COMMUNITY DEVELOPMENT DEPARTMENT
501 Delta Avenue ♦ Marysville, WA 98270 ♦ (360) 363-8000

February 13, 2024

Re: Harborview Heights – Technical Review 1
SP23-007

After reviewing the application materials for the above referenced proposal, the following technical review comments are provided:

DATE: 5-Aug-24
JOB NO: 2023 052
DRAWN: SH
CHECKED: EN
REVISION:
SITE/UTILITY PLAN
SHEET: SP-01

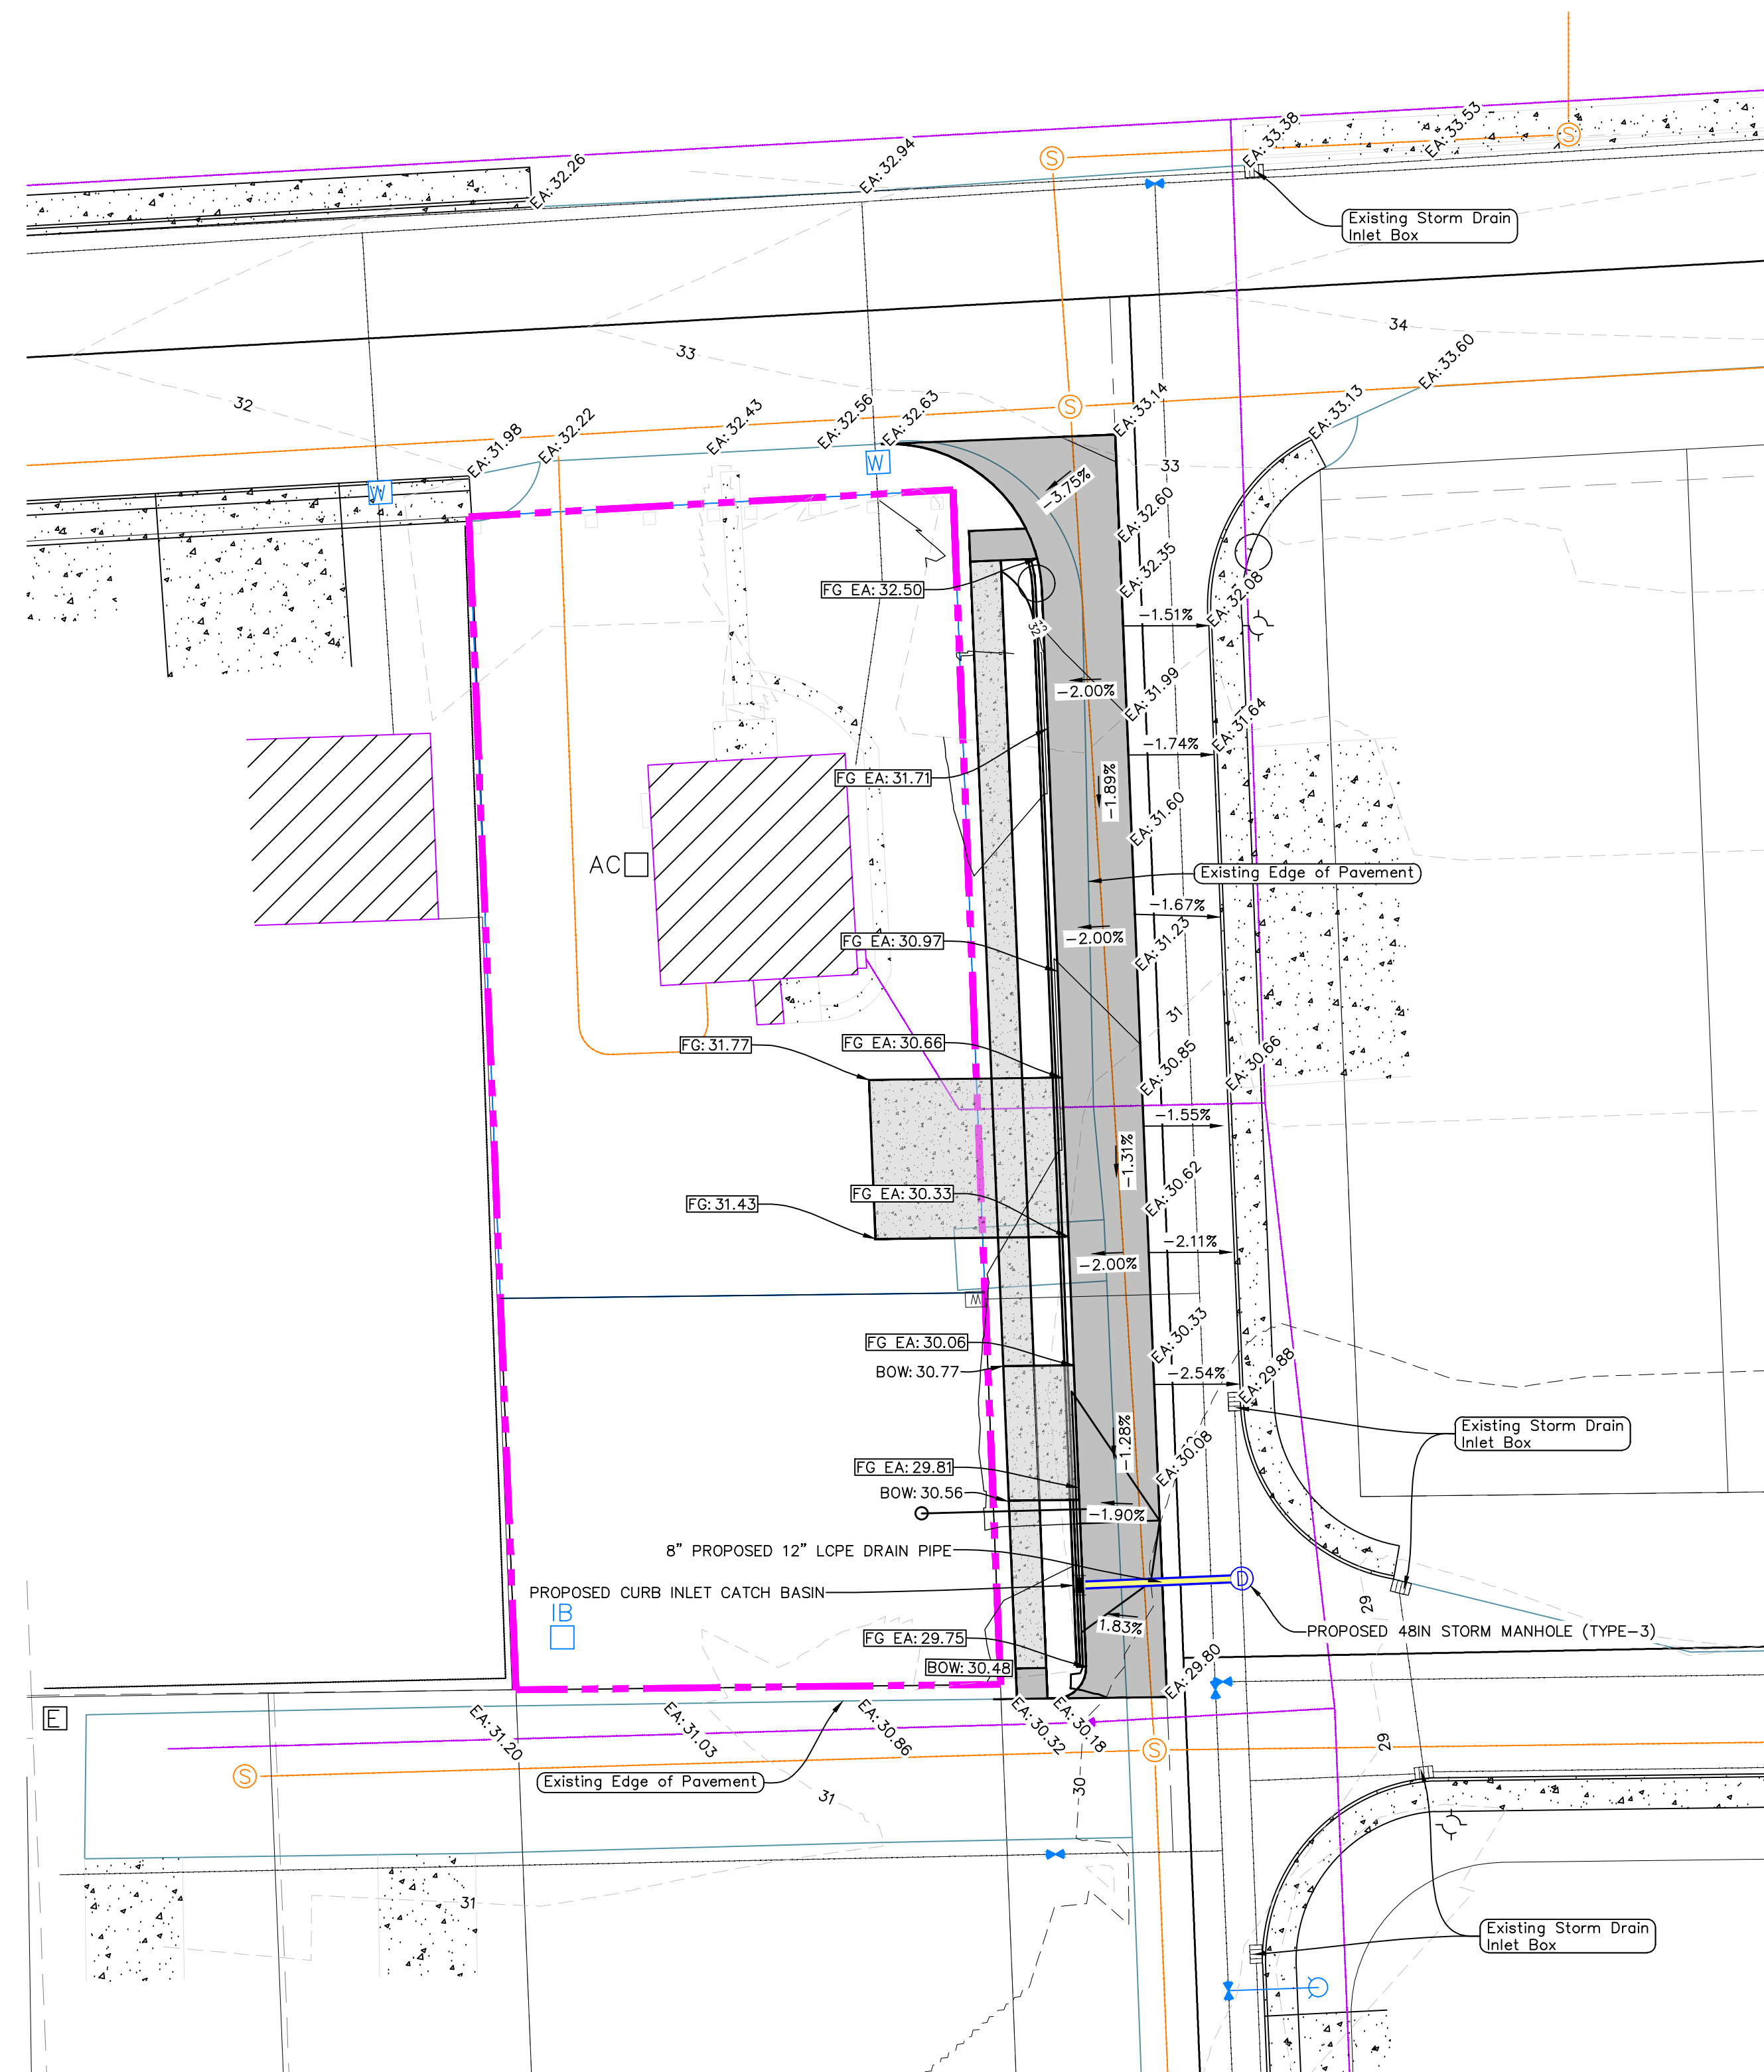
8. Amend sheet SP-01 to depict existing side sewer service to the existing house on lot 1.
9. All subdivisions or short subdivisions shall have all necessary power lines, telephone wires, television cables, fire alarm systems and other communication wires, cables or lines placed in underground location either by direct burial or by means of conduit or ducts and, with the exception of the city fire alarm system, providing service to each lot or potential building site in the plat. This include the existing overhead utilities for lot 1.

HARBOR VIEW HEIGHTS
SHORT PLAT
NUMBER SP23-007

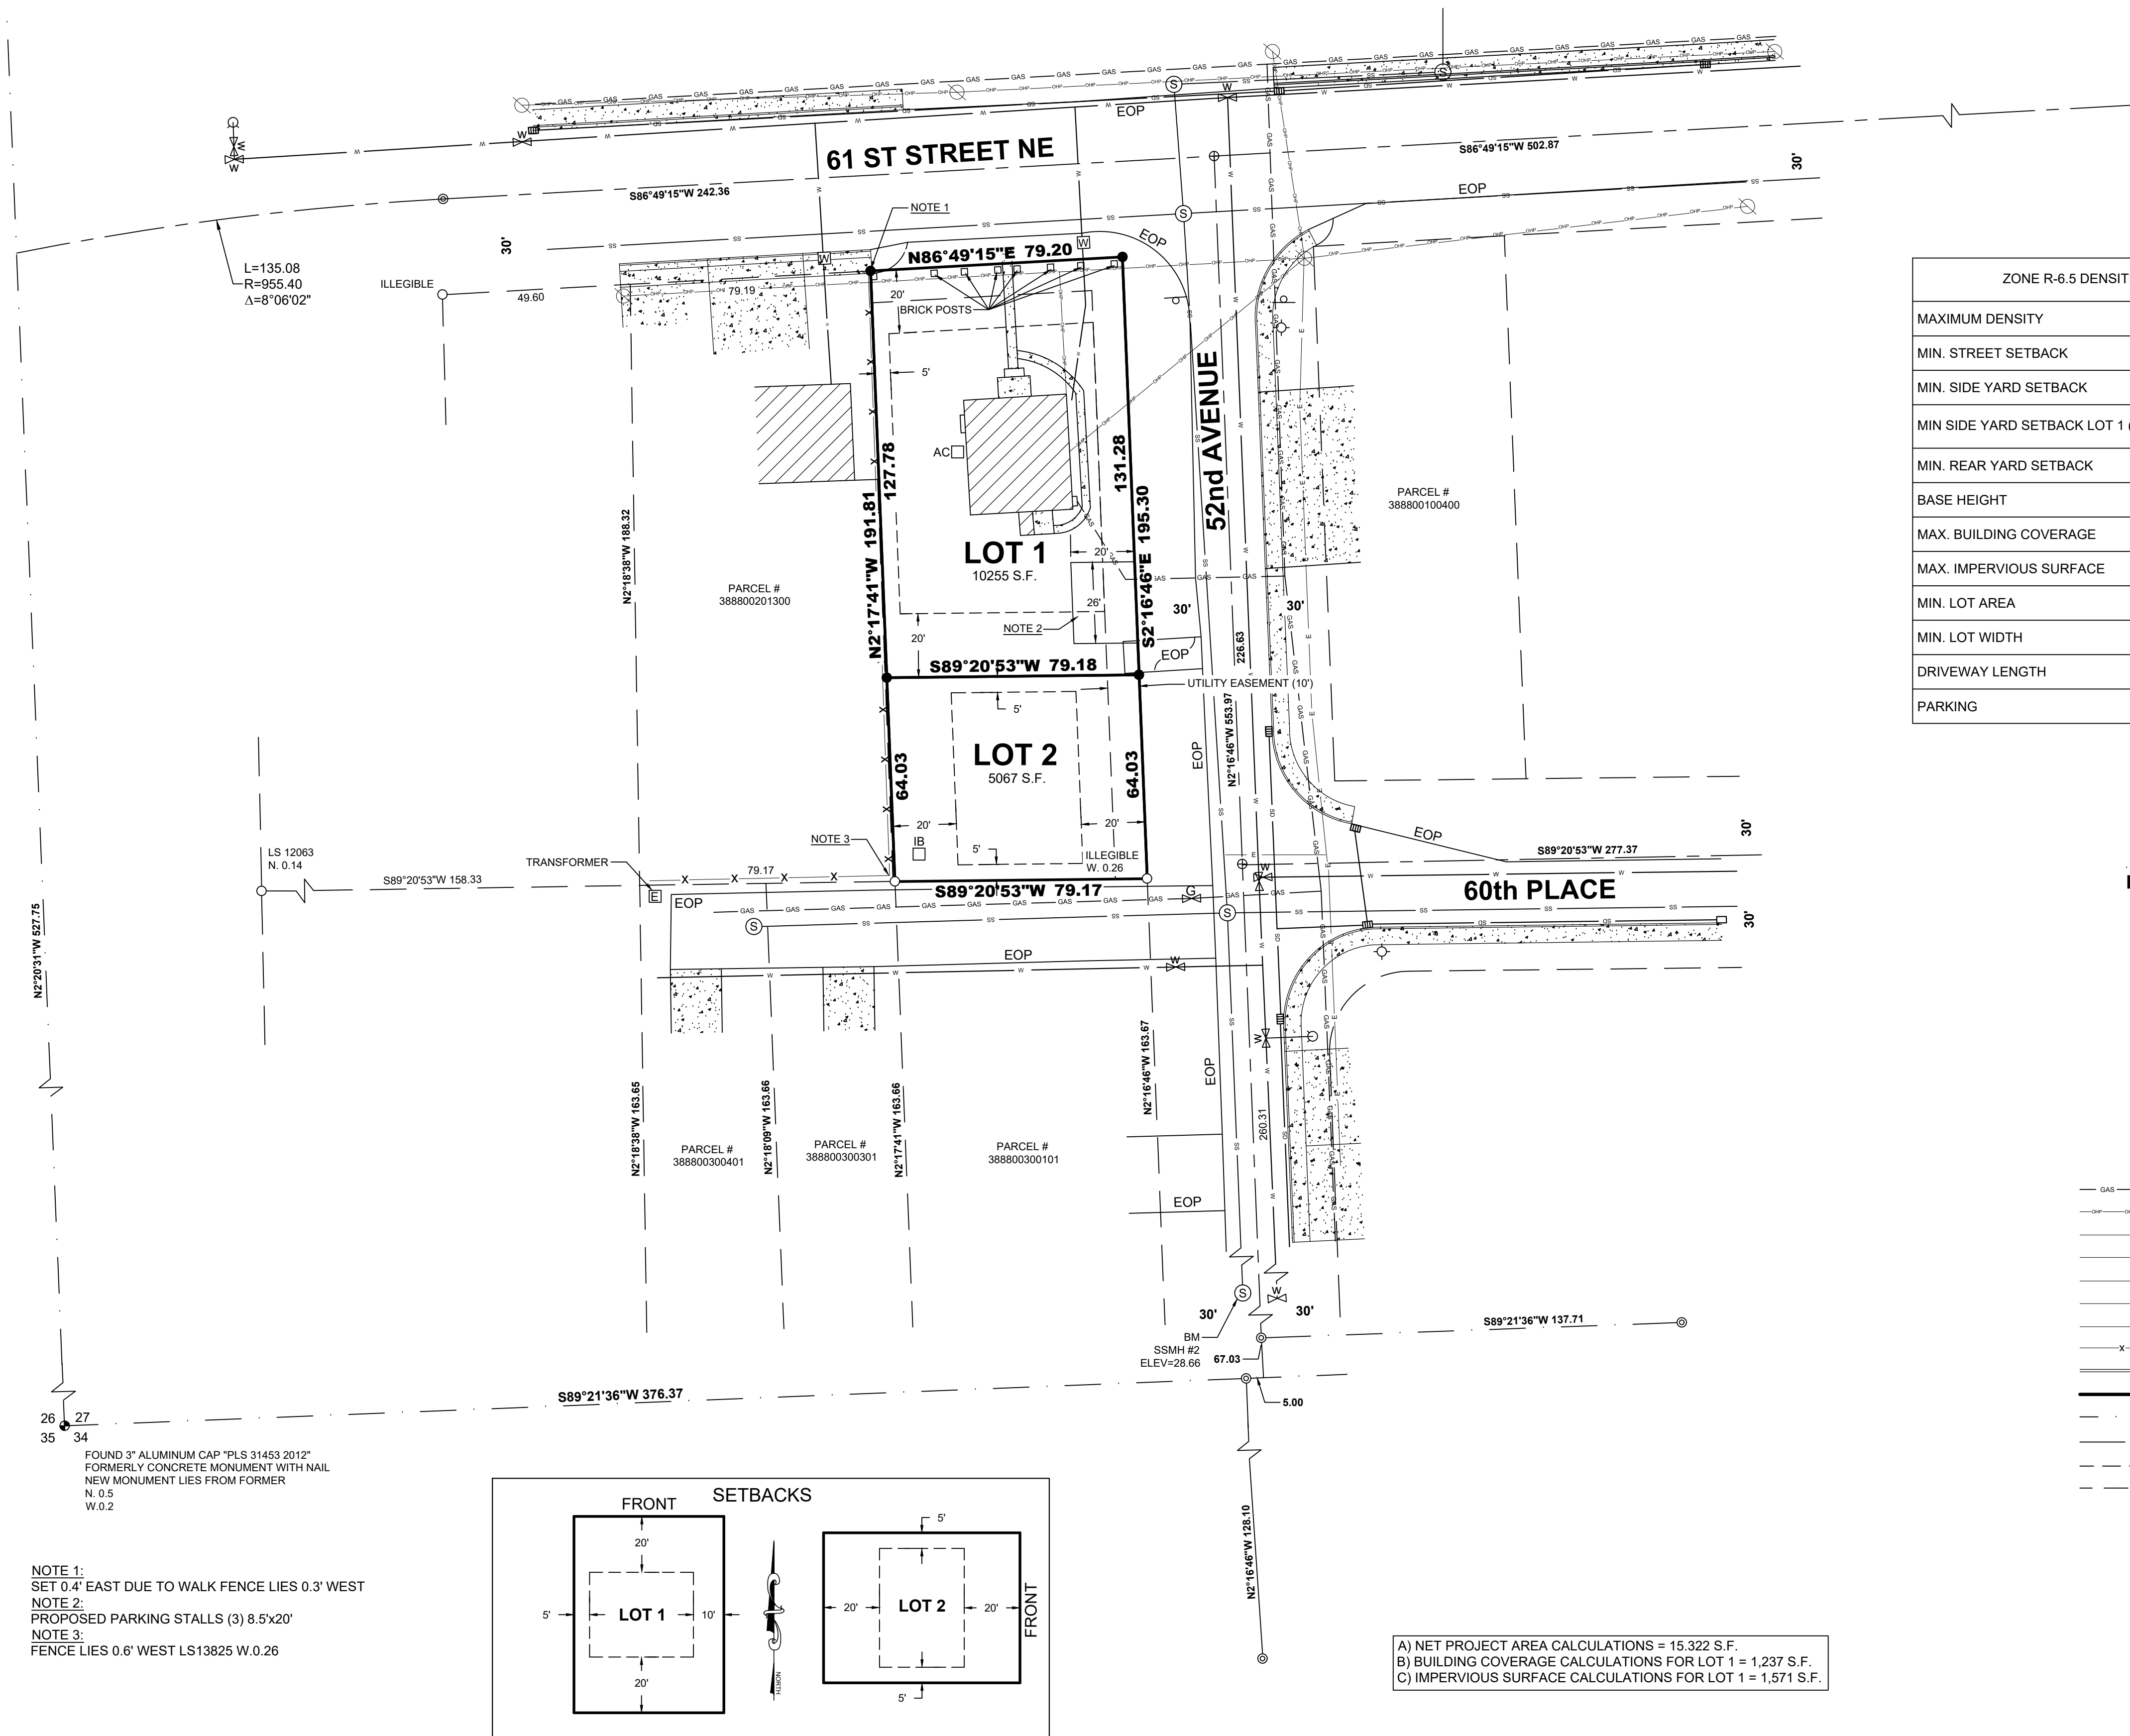
1. Please include file number SP23-007 on all future maps.
2. Show the following setback lines on the preliminary short plat map:
 - a. Lot 1:
 - i. Front yard 20ft
 - ii. Rear yard 20ft
 - iii. Side yard (52nd Ave) 10ft
 - iv. Side yard (west) 5ft
 - b. Lot 2:
 - i. Front yard 20ft
 - ii. Rear yard 20ft
 - iii. Side yards 5ft

3. Amend the preliminary short plat map, to include the following table:

4. Amend the preliminary short plat map to include the following:
 - a. Net project area calculations (see definition in [MMC 22A.020.150](#))
 - b. Building Coverage calculations for lot 1
